From: Michael Eastham
Sent: 17 December 2020 14:16
To: Planning Scanning
Subject: FW: A/166/20/DOC - Manor Nursery, High Street, Angmering

Please scan and upload the email below from the applicant confirming that we have an extension of time (EoT) to determine discharge of condition application **A/166/20/DOC** to Tuesday **12th January 2021**.

From: Laura Gibbons [REDACTED]
Sent: 16 November 2020 11:07
To: Michael Eastham <Michael.Eastham@arun.gov.uk>
Cc: Paul Cann <Paul.Cann@arun.gov.uk>
Subject: Re: A/166/20/DOC - Manor Nursery, High Street, Angmering

TITLE Proposed Site Surface Water Network Area Plan	
SCALE 1:500 @ A3	DRG. No. 60

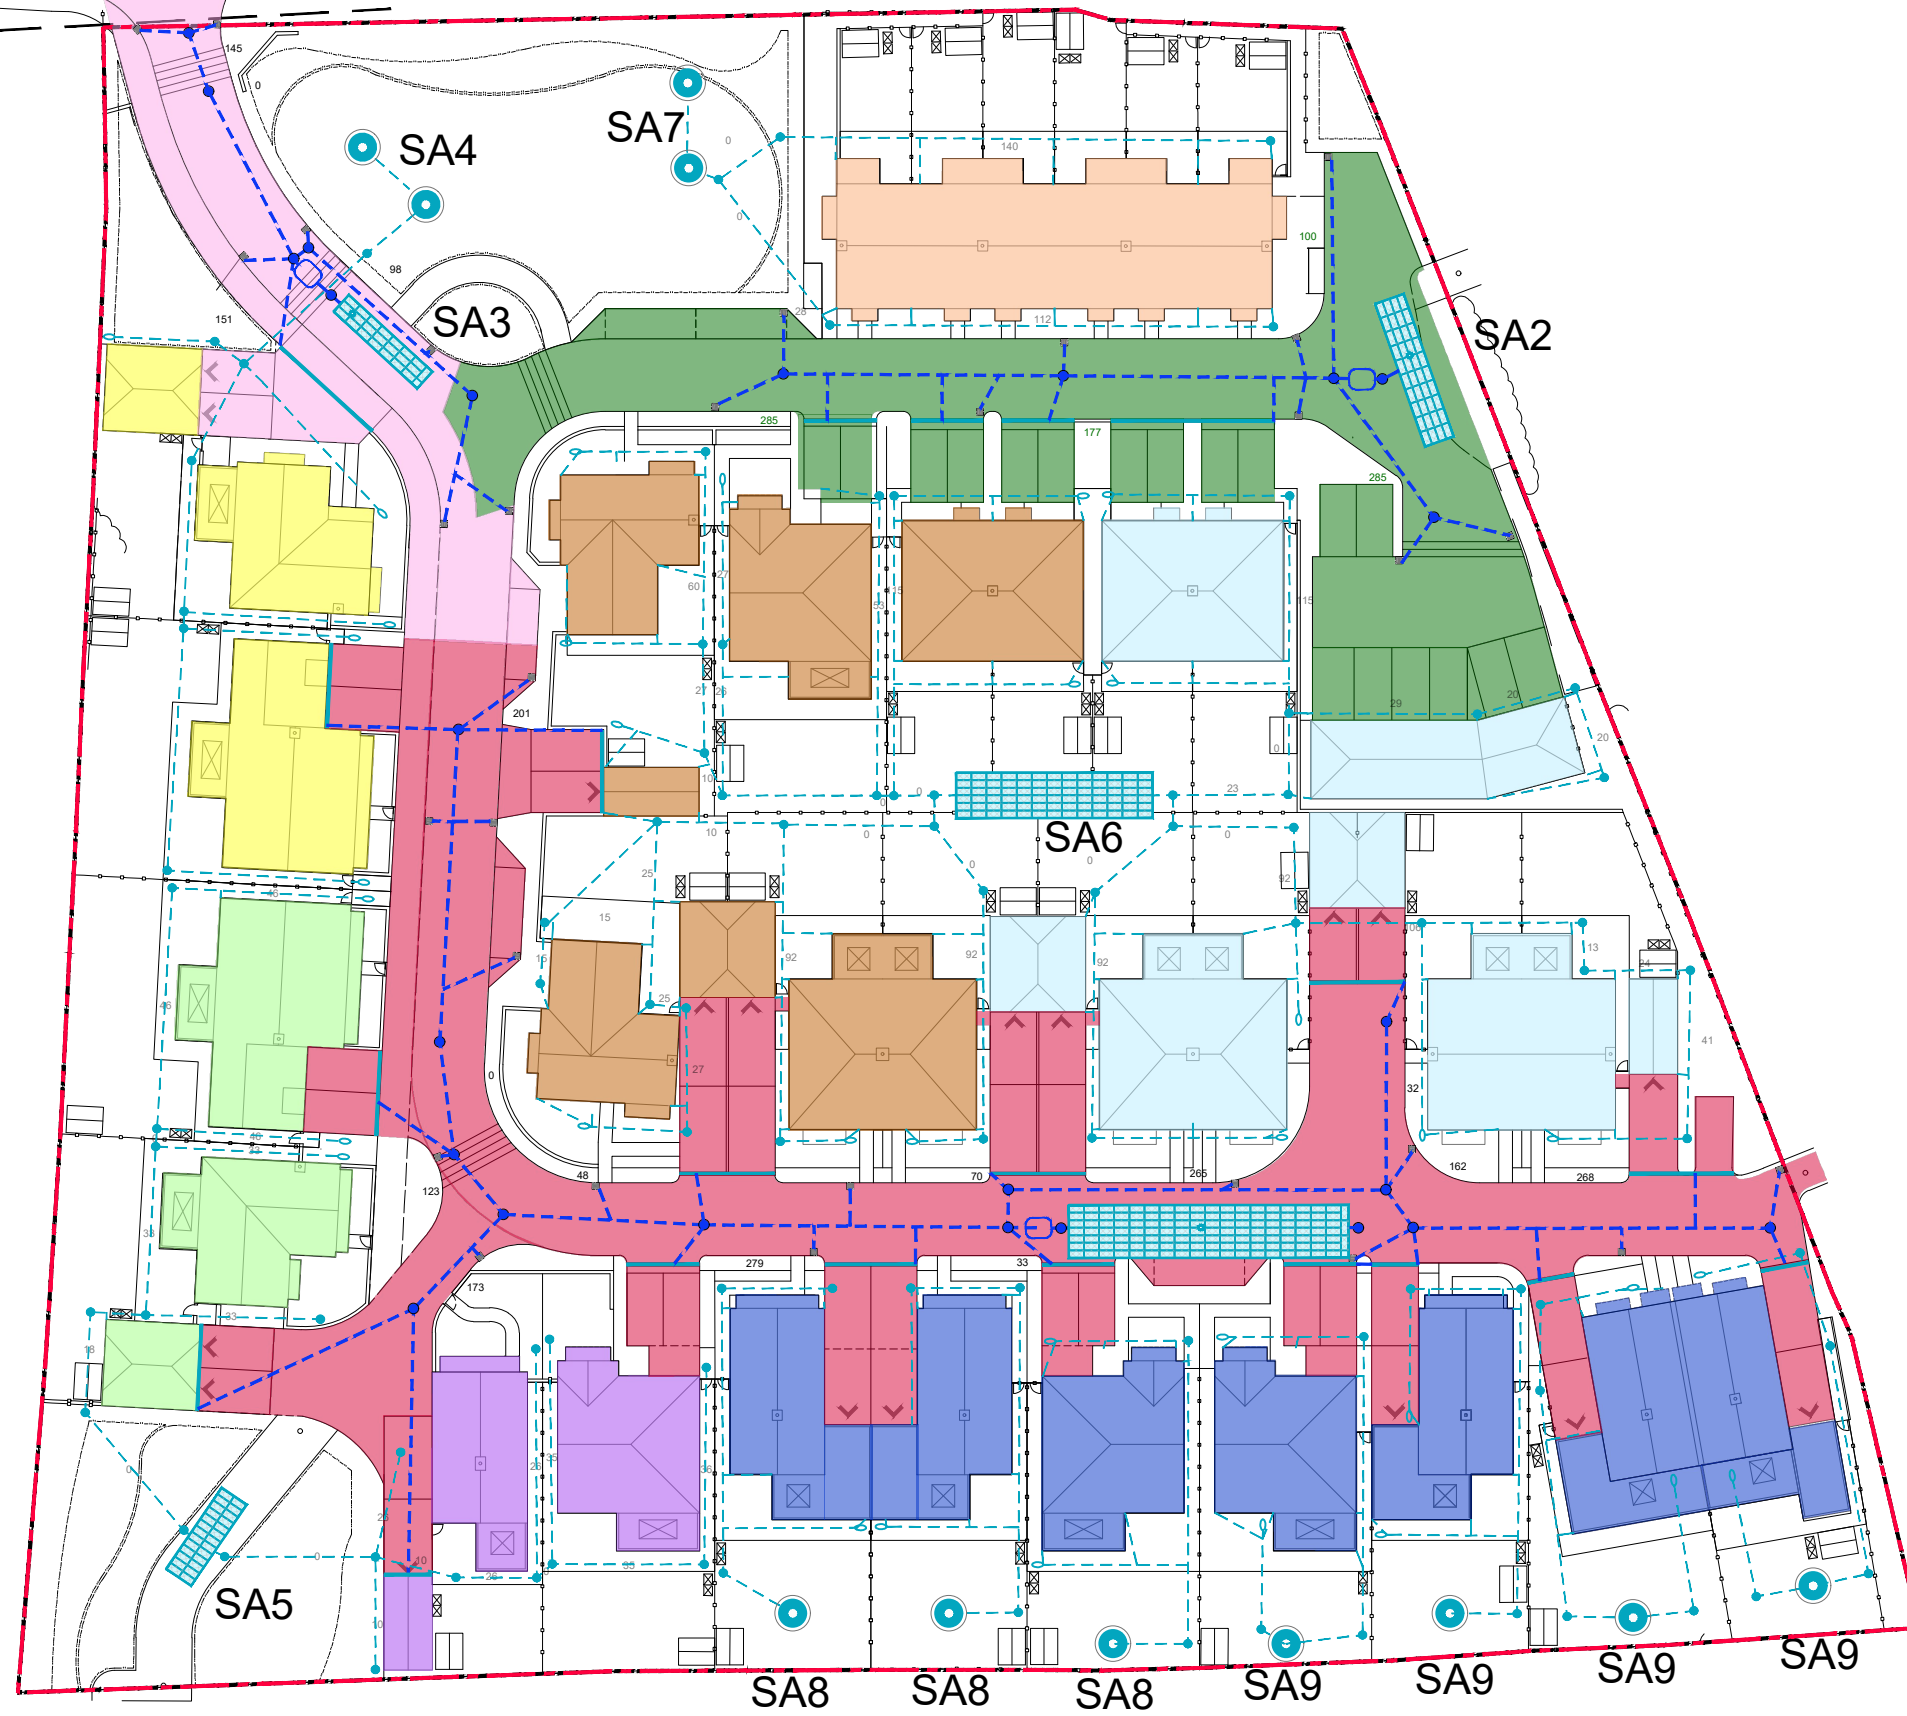
1. The impermeable areas plan supplied does not clearly show the areas draining to each soakaway. E.g. the areas draining to soakaways 8 and 9 are poorly defined. Please can the applicant supply a better impermeable areas plan which clearly shows the areas draining to each soakaway and which areas have had 10% urban creep allowance applied. 60_Network Areas Plan has now been updated for clarity and the drainage areas for SA 8 and 9 is now more clearly defined. The plan also now shows which areas have Urban Creep of 10% applied to them in the key.

CLIENT Roffey Homes Ltd	
PROJECT Manor Nurseries Site Angmering	
TITLE Proposed Maintenance Ownership Plan	
DRAWN P Reynolds	DATE Dec 2020
ENGINEER S Burgess	CHECKED
SCALE 1:250 @ A1	PROJECT NO. 22995 Dwg. No. REV. 120

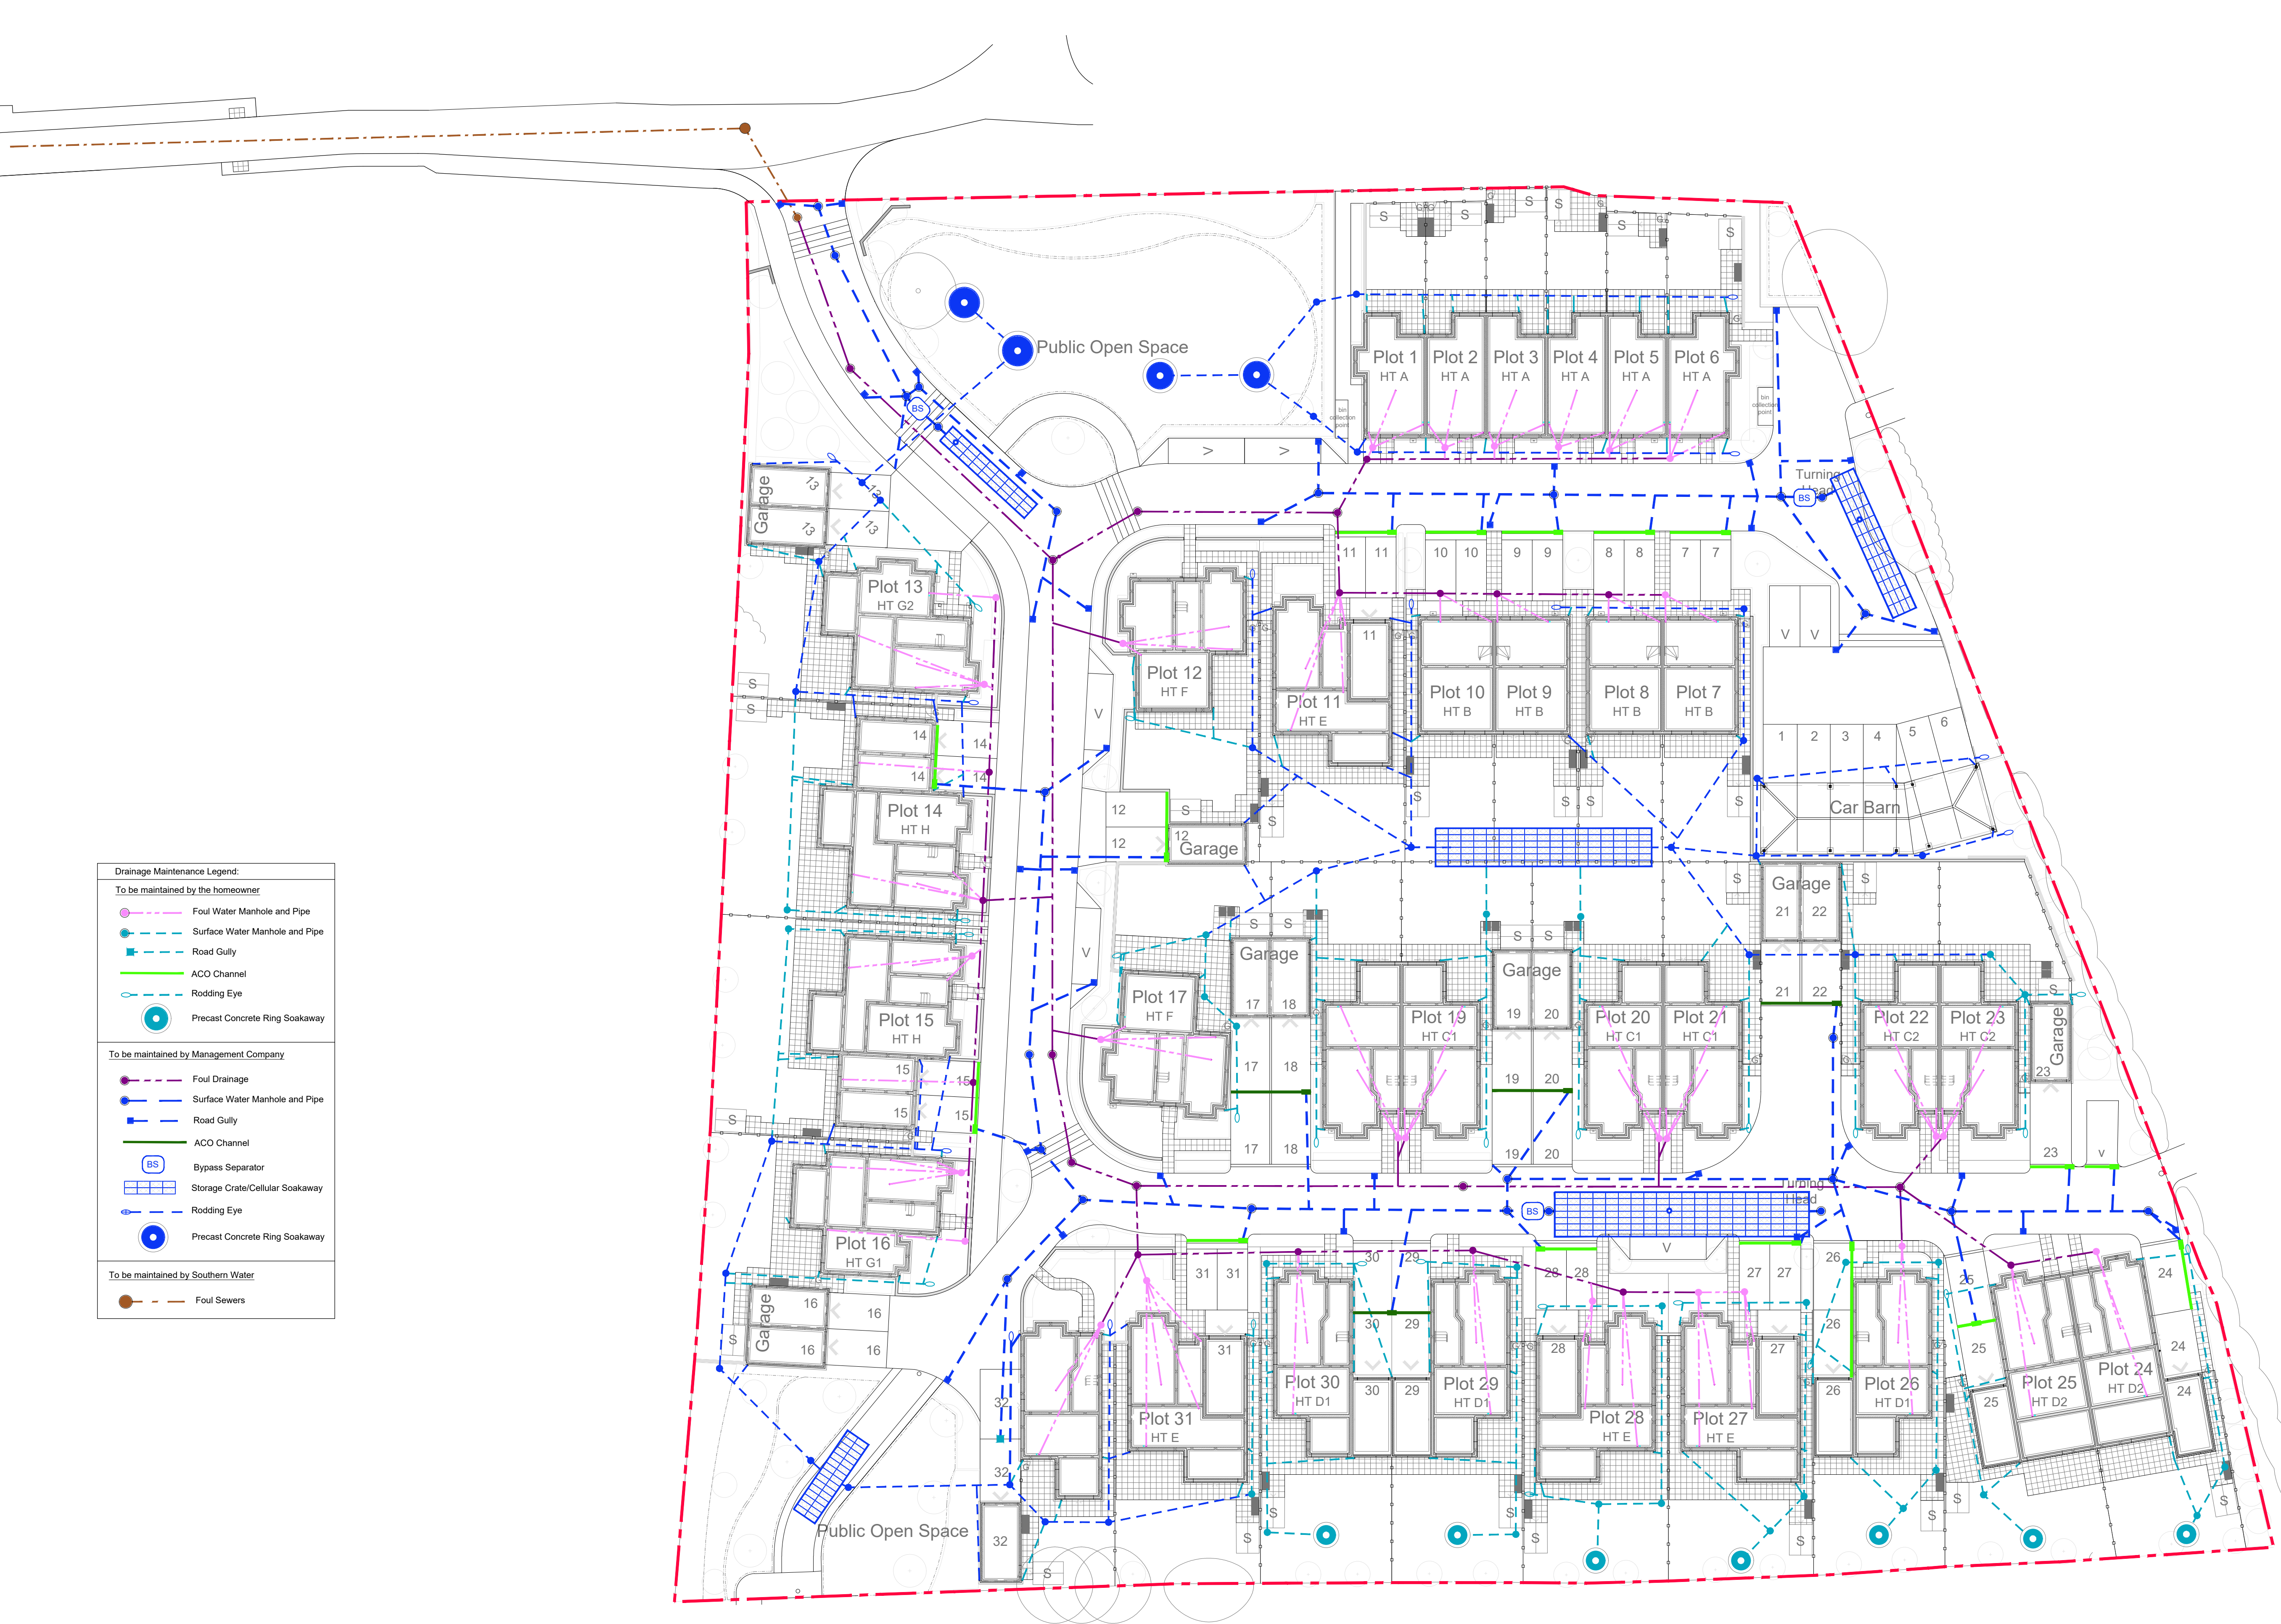
3. (Relating to previous comment no. 10) The maintenance manual does not specify how maintenance will be funded, I presume a charge will be levied on residents and this will be included within the deeds. Please detail how money is to be secured.

4. (Relating to previous comment no. 10) Please detail the requirements for maintenance of the infiltrating components, e.g. look at table 13.1 in C753.
